Ref: APPROVAL. 2008/0551 : 47 DARTON ROAD, CANTWORTH

Our clients wished to carry out revisions to the approved elevation details as you considered at the time these could be treated as amendments to the original approval.

PROPOSED ELEVATIONS 1:100,

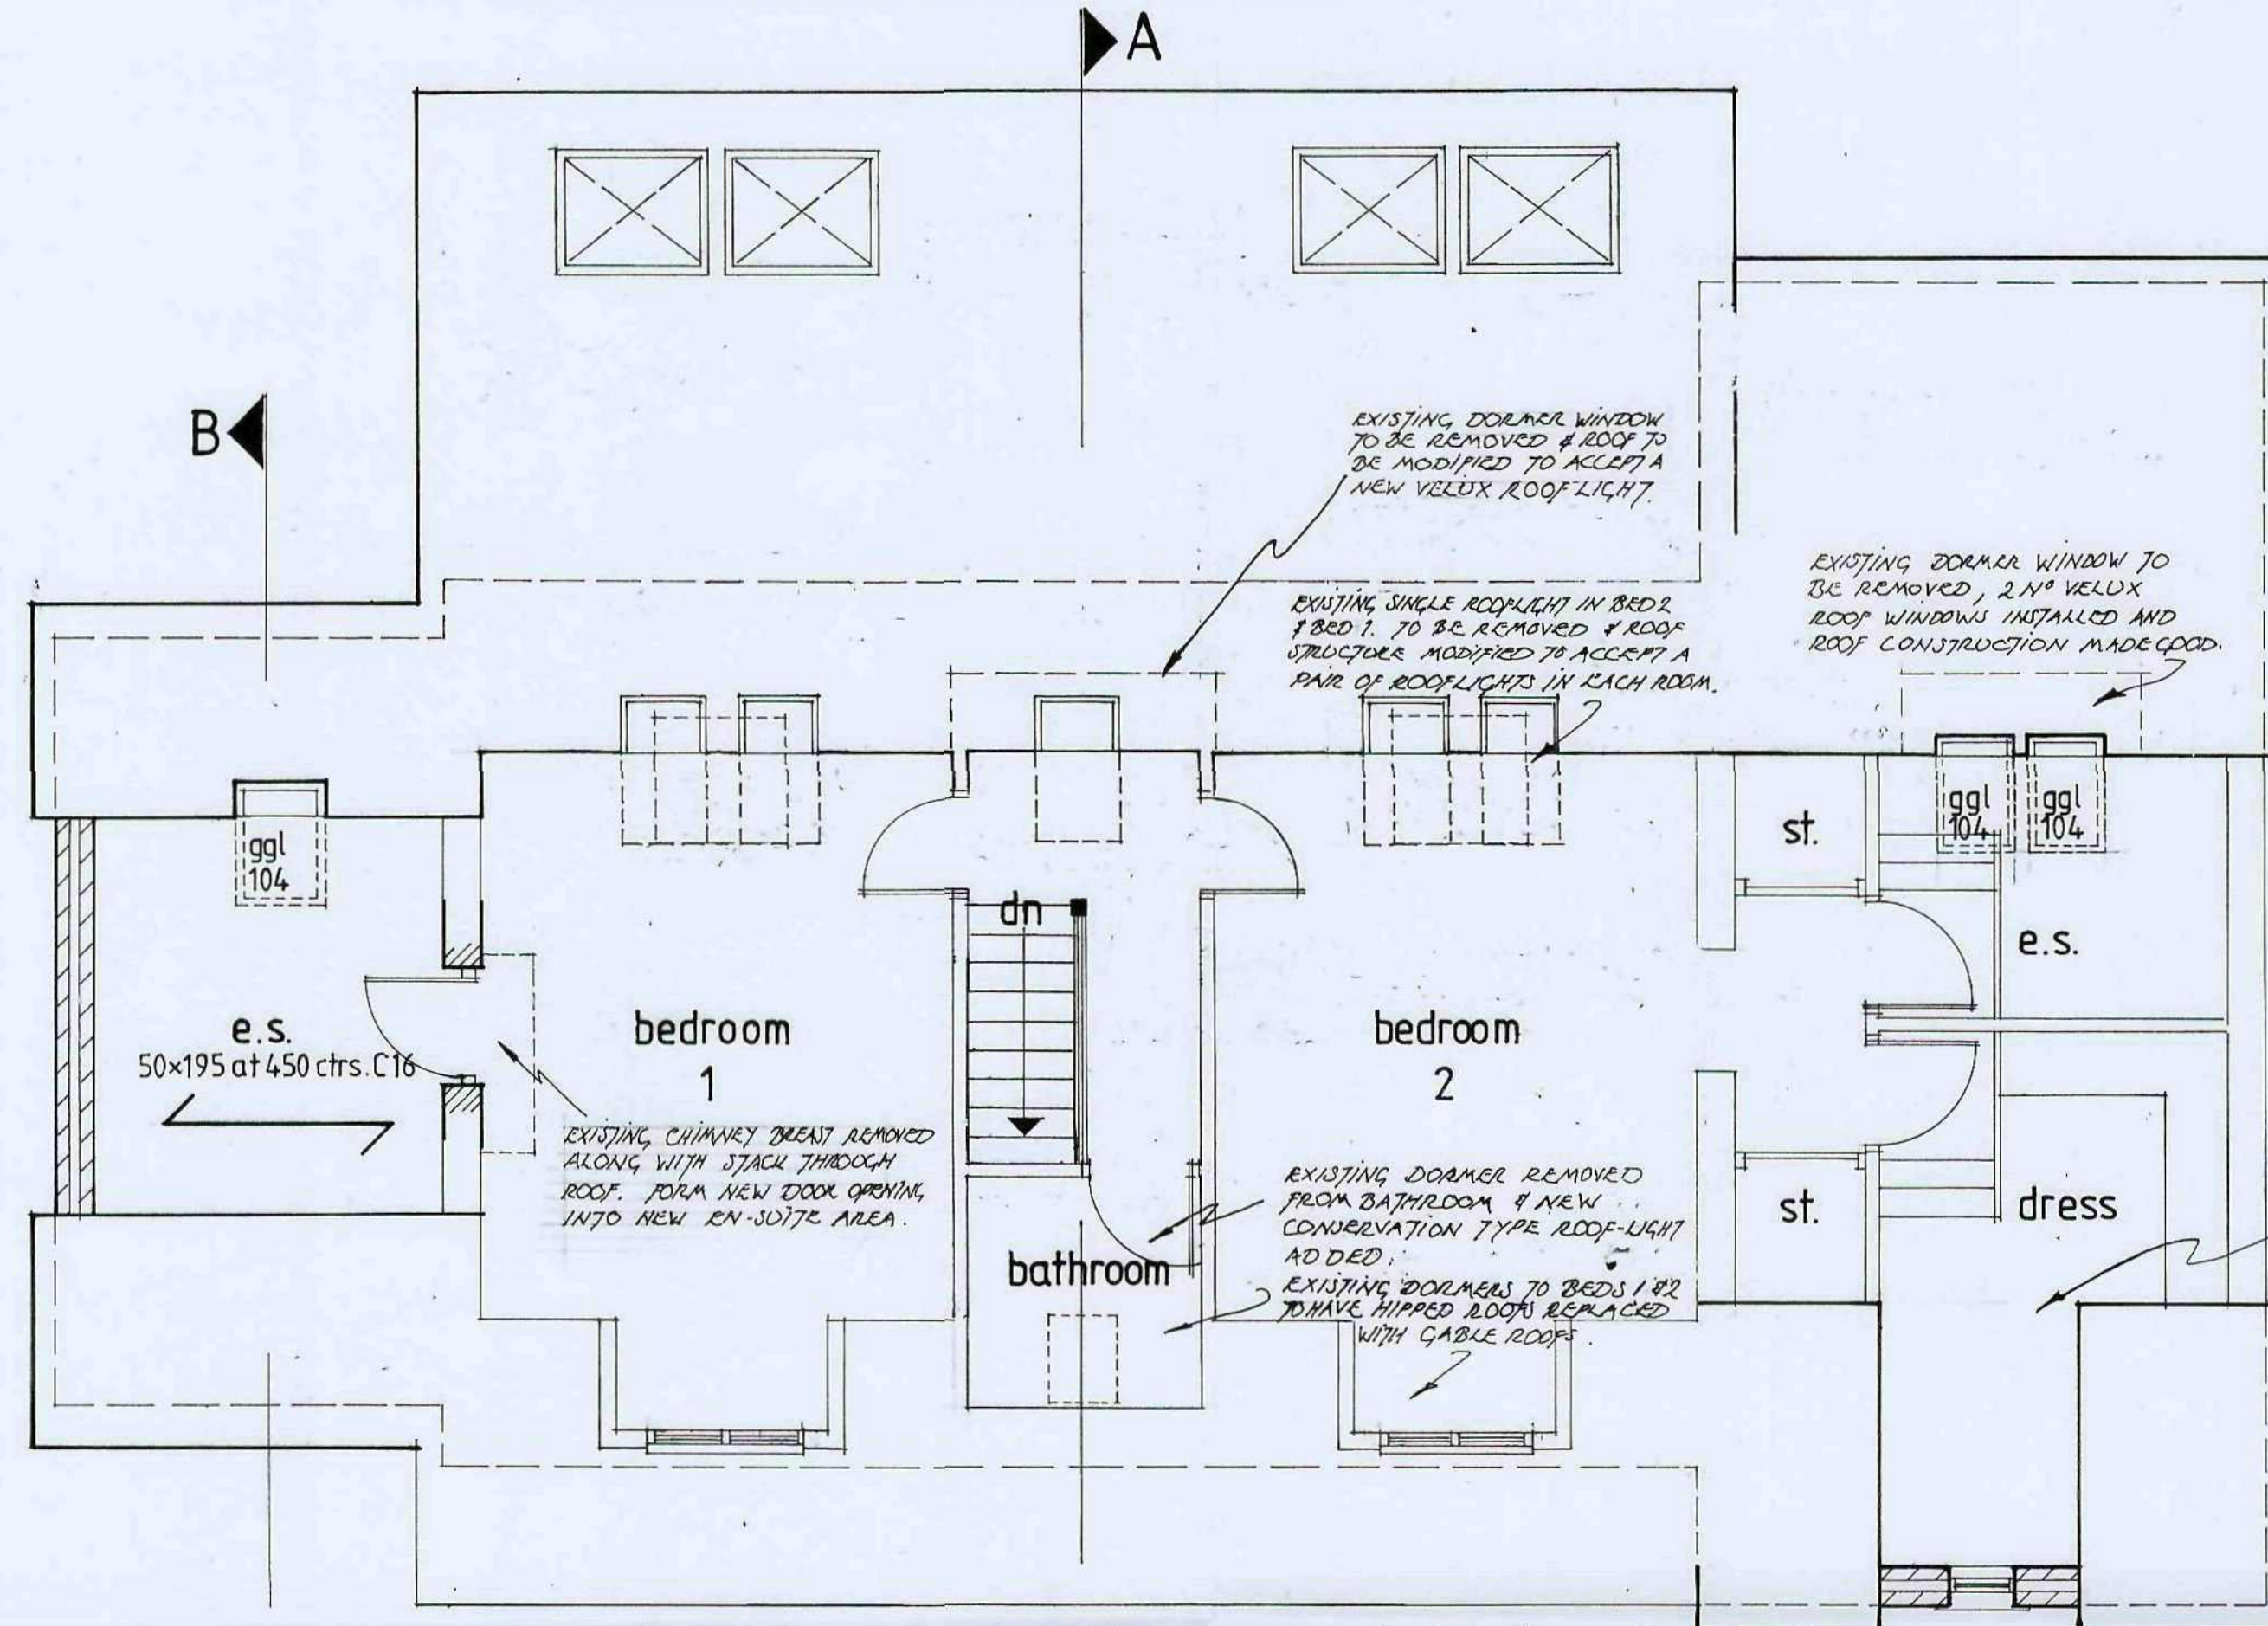
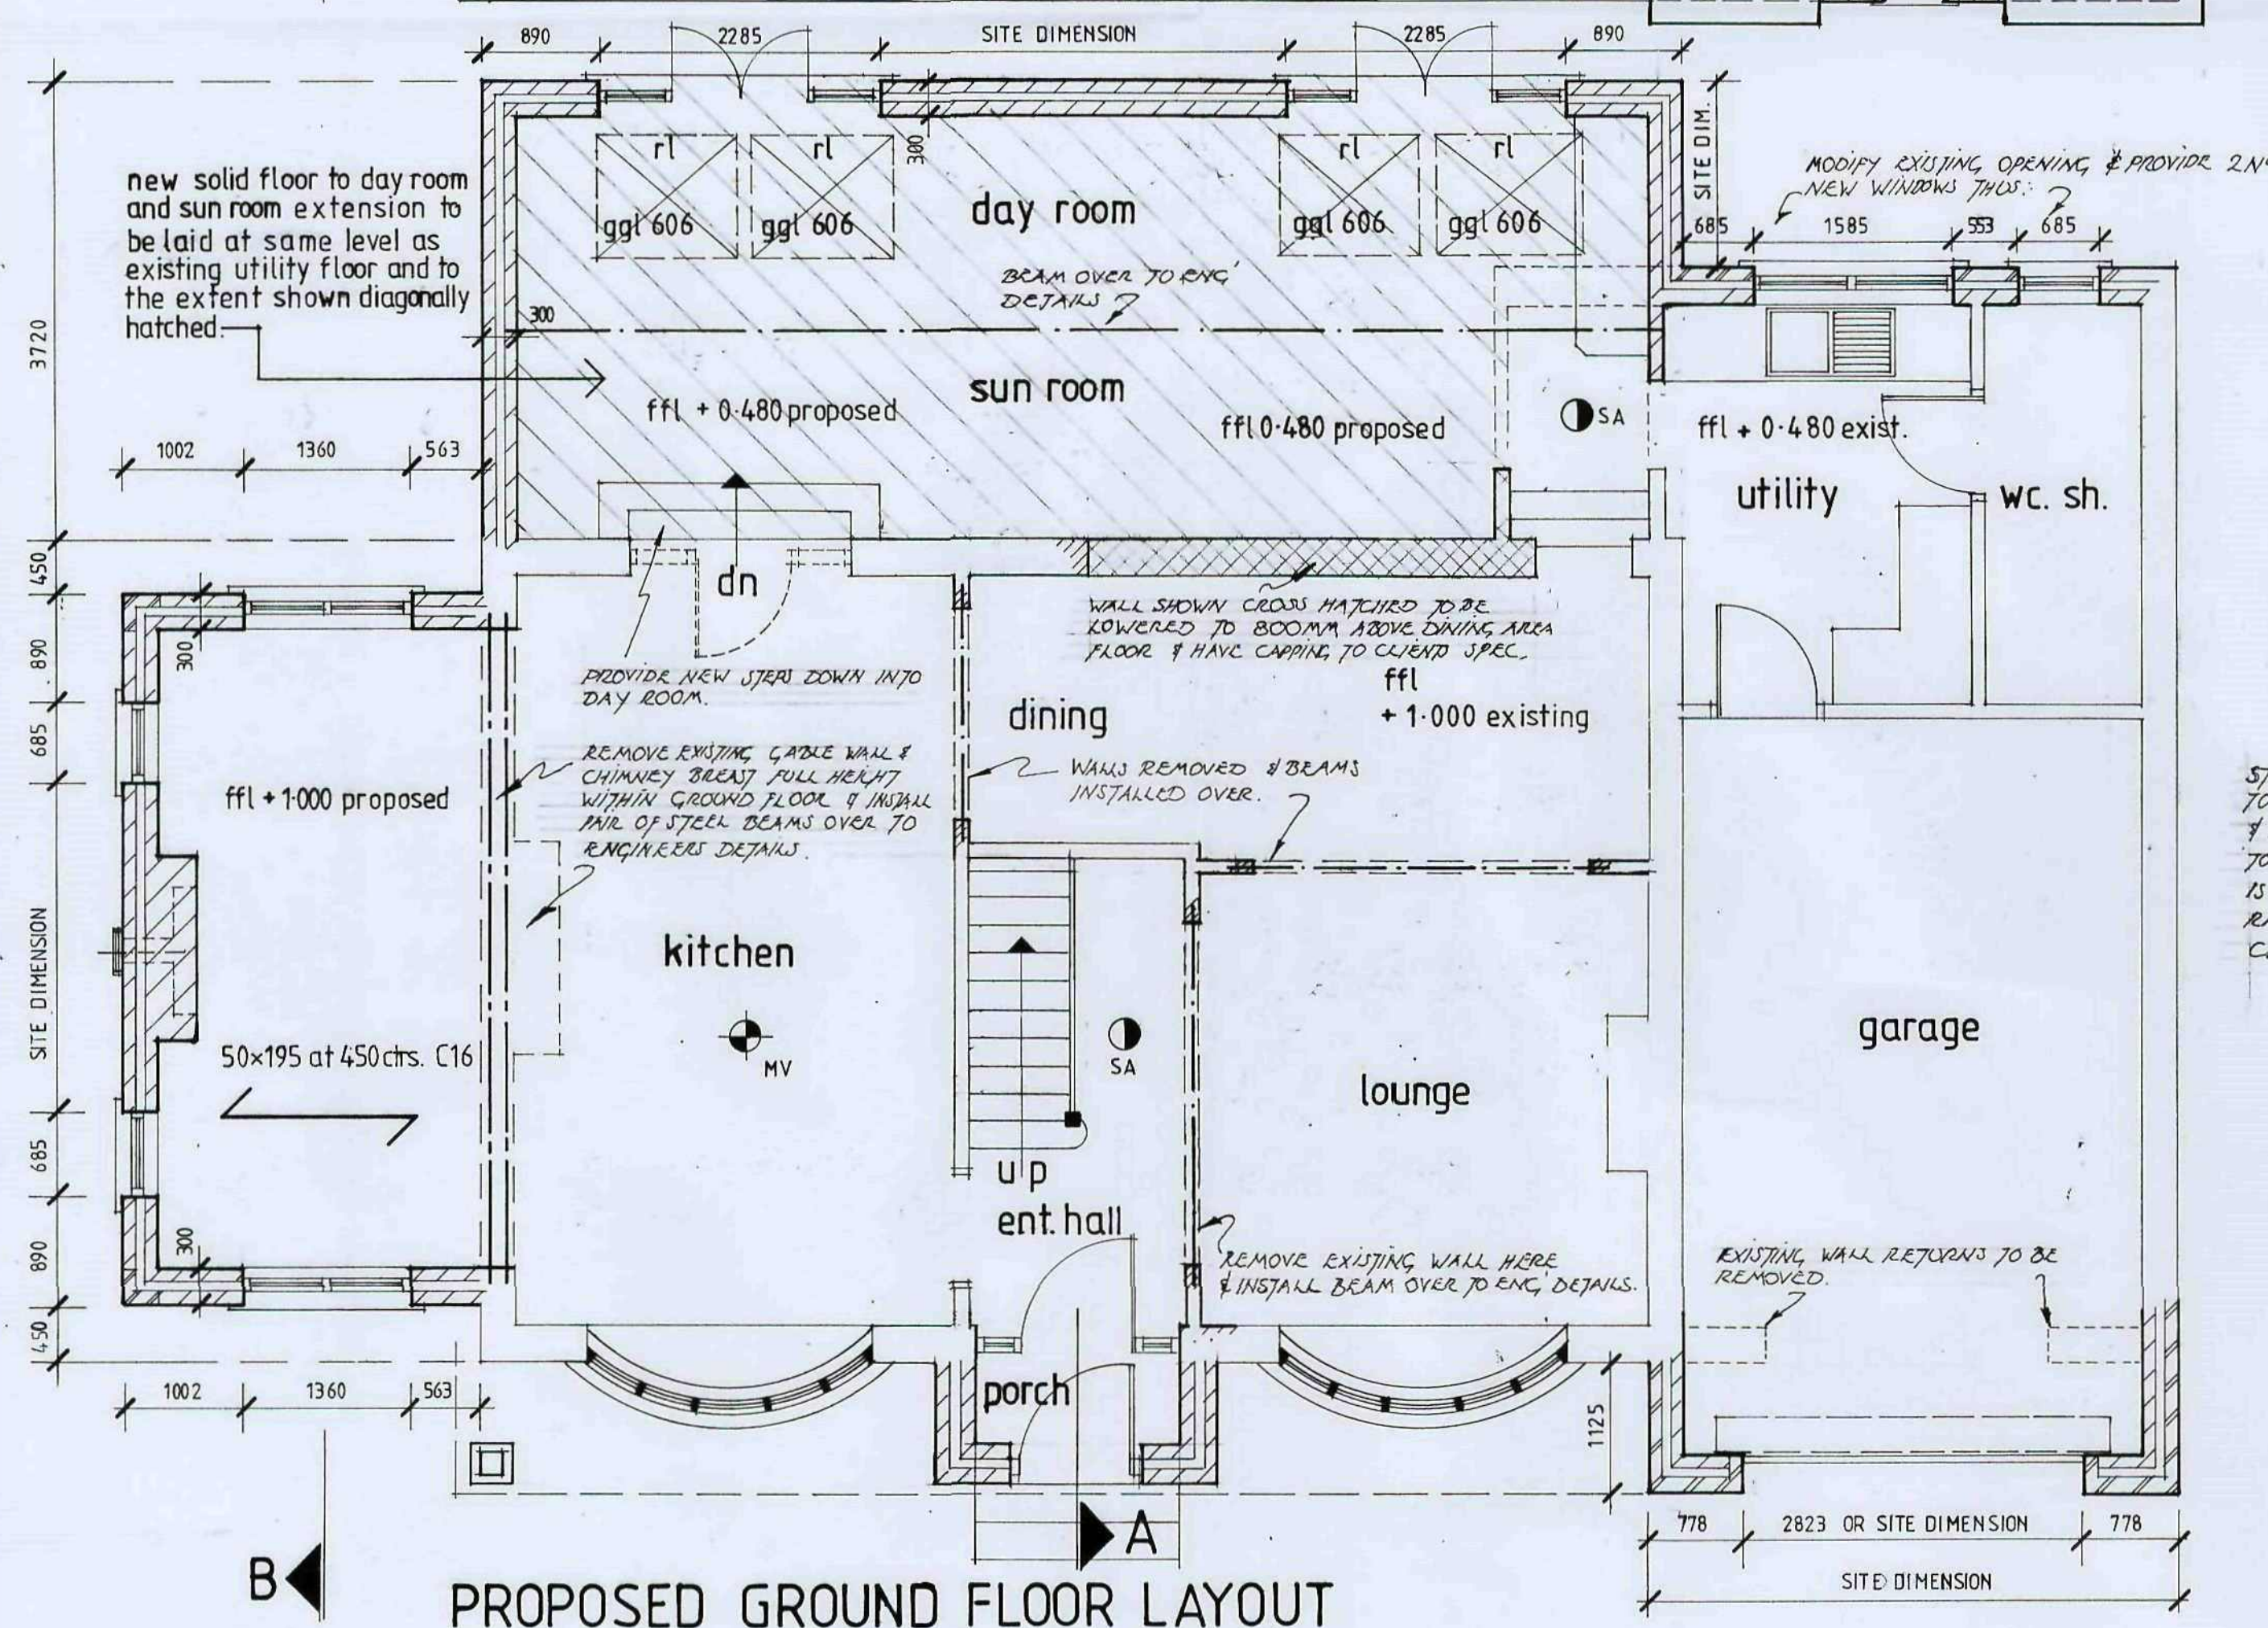
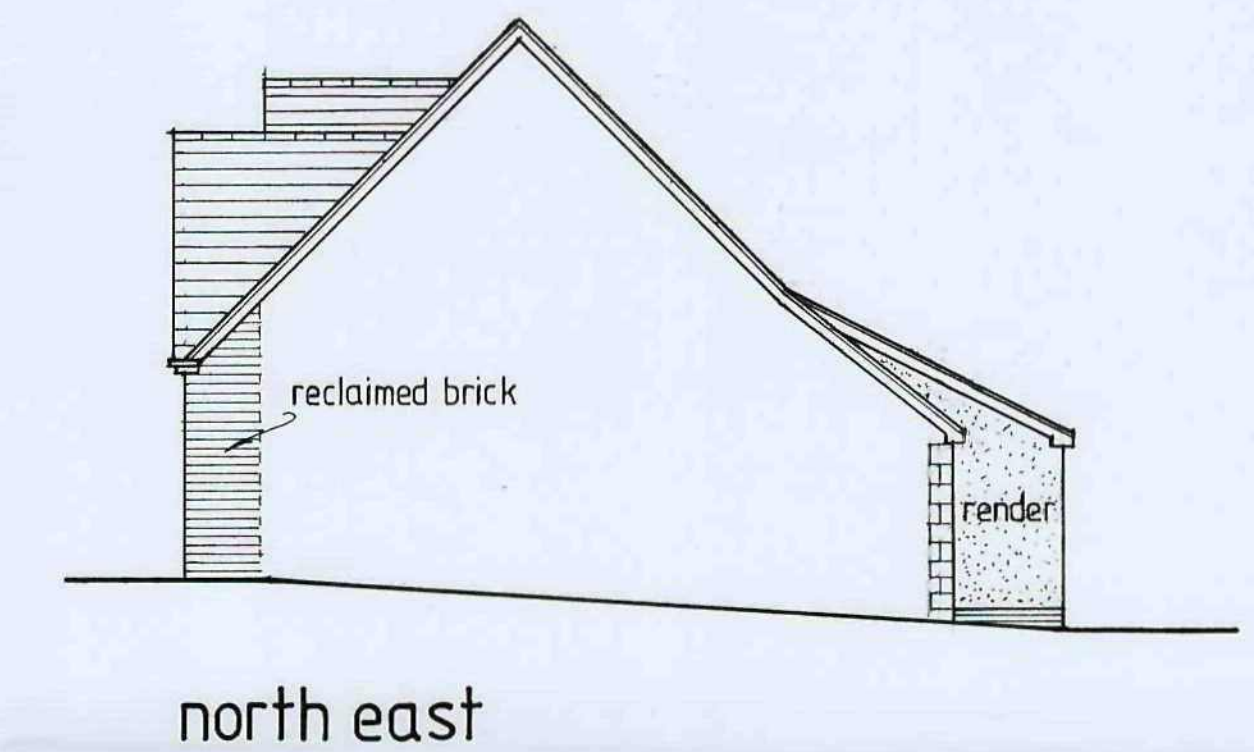
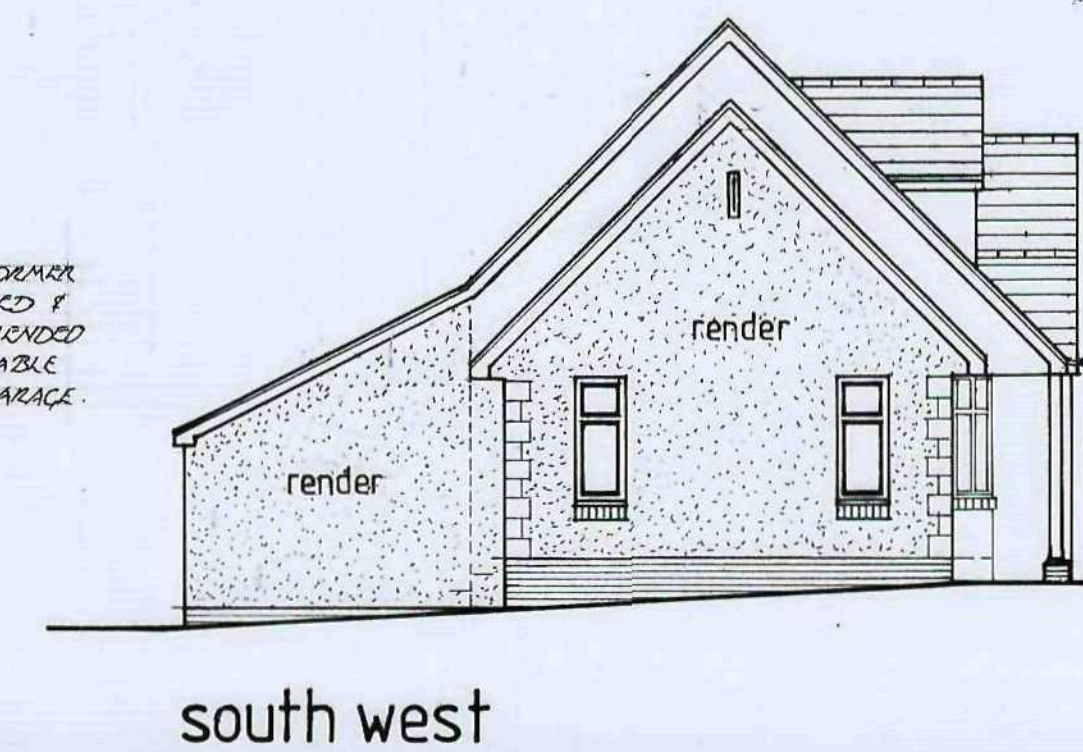
We enclose 2 copies of drawings with the revisions highlighted for clarity & we look forward to your confirmation that these are acceptable at your earliest conv.
Kind regards. Peter
